From: Linda Griffiths
Sent: 04 February 2020 14:23
To: DC Support
Subject: FW: SW Bicester KMC KMD (Persimmon Homes) - LAP Planting and Tree Pit Details

Re 19/02729/DISC
Thanks

From: Tim Screen <Tim.Screen@Cherwell-DC.gov.uk>
Sent: 04 February 2020 10:43
To: Linda Griffiths <Linda.Griffiths@Cherwell-DC.gov.uk>
Subject: SW Bicester KMC KMD (Persimmon Homes) - LAP Planting and Tree Pit Details

Title **Detailed Planting Plan Sheet 5 of 6**

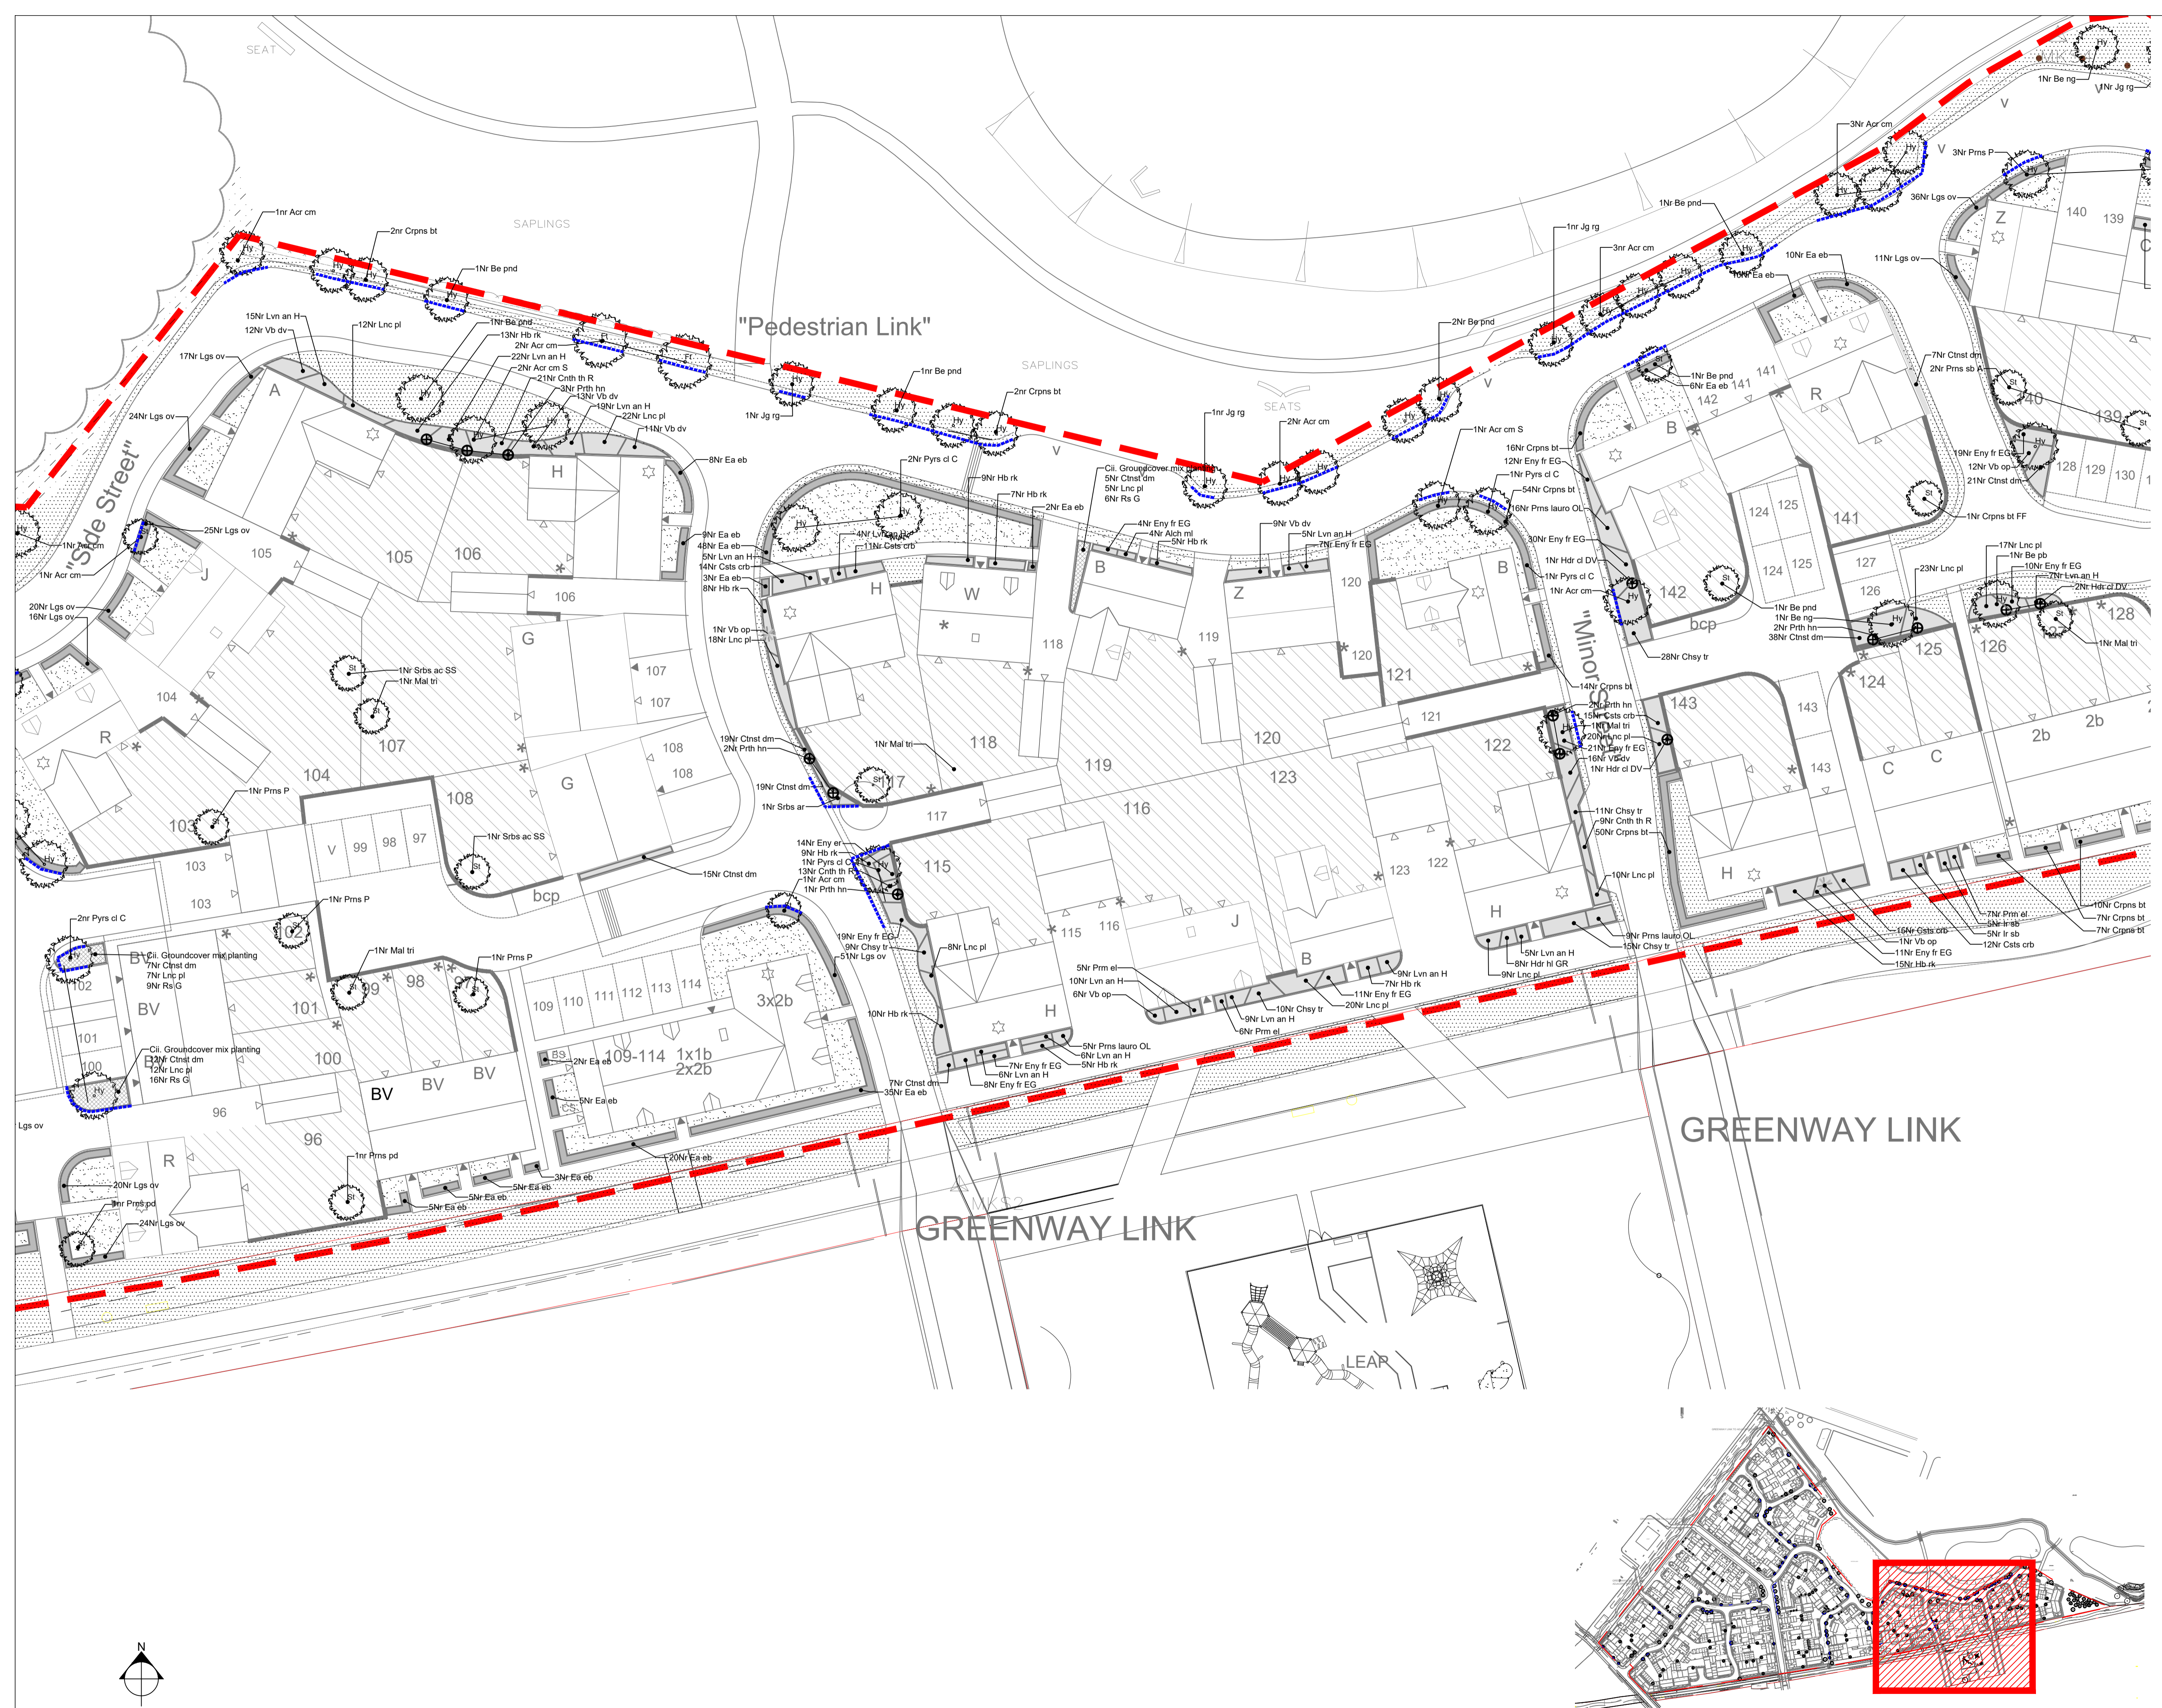
1. The 3 no Carpinus betulus, Hornbeam are forest trees and have a potential to reach 17 – 22 m (according to Barcham Trees). They are therefore deemed by me to be ultimately too big for this play area. The canopy spread will mean that bird droppings and detritus from the tree will contaminate the play equipment with regular (and costly) cleansing necessary. The roots will be invasive and cause structural damage to paths and play safer surface. For the same tree positions replace the hornbeams with 3 no .Amelanchier lamarkii, Snowy Mespilus, 14 -16 cm.

2. Prunus avium is again too large for the space and its roots will cause structural damage to paths and play safer surface. Replace with Betula pendula 'Obelisk' with root barrier on the path side.

3. Replace the softer ('trashable') Heuchera and Stachys in the areas near the entrance with a more robust plant species, Lonicera pileata
4. Pittisporum tend to be not so frost hardy.

5. The rather heavy soil should be improve with horticultural grit to improve drainage for the Mediterranean species. Cold wet soils will kill such plants.
